Reference LU/184/19/HH
14 Esher Drive, BN 17 6AA

My objections to the above plans for the bungalow are as follows:

Proposed Front (west) Elevation
Scale 1:100

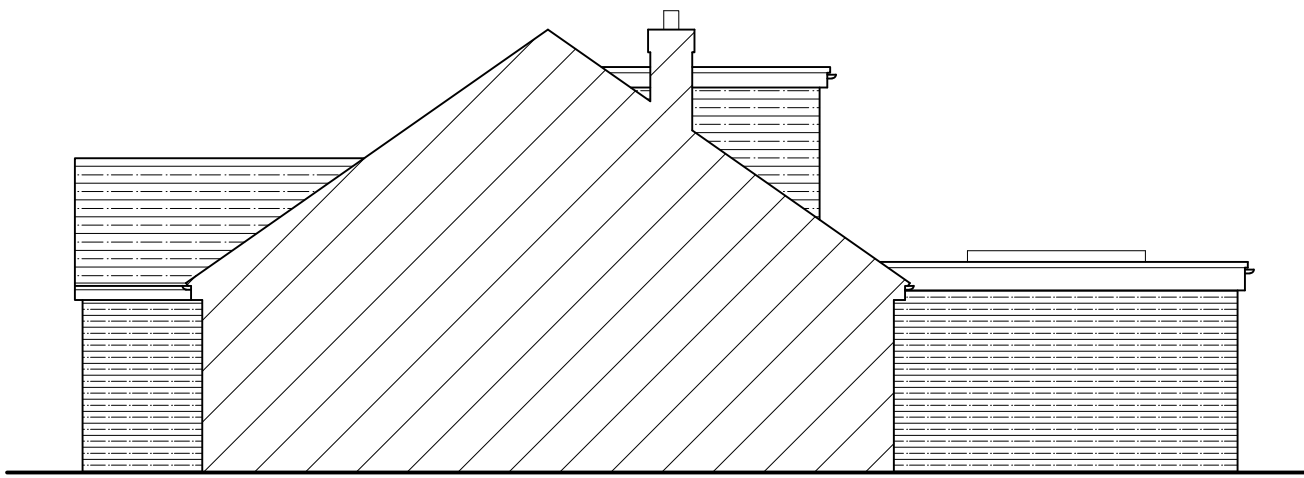
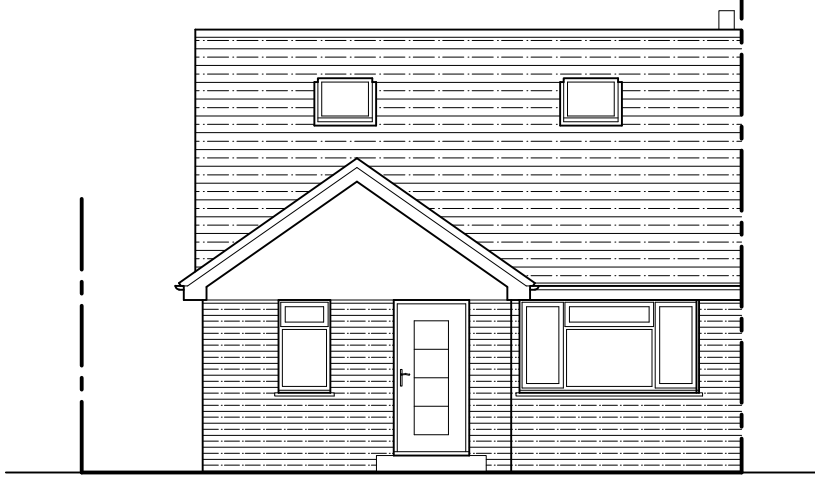
1. There are no extensions to the front of the bungalows in Esher Drive therefore surely the proposed porch and dormer windows would alter the building line.
2. All the proposed extensions front and back would make a house in the middle of a road of similar sized bungalows without these additions. Bungalows in this road are sought after as we are mostly a retired community and this is the reason we bought into it. The addition of this sized property would then make it difficult for us to sell and could have a detrimental effect on the price we could get.
3. The fact that there would be such a large house in such a small space would also cause a noise problem. The gardens are not huge so any extension has got to have an effect on the noise and also the light.
4. There must be consideration for the fact that we have a shared drive.
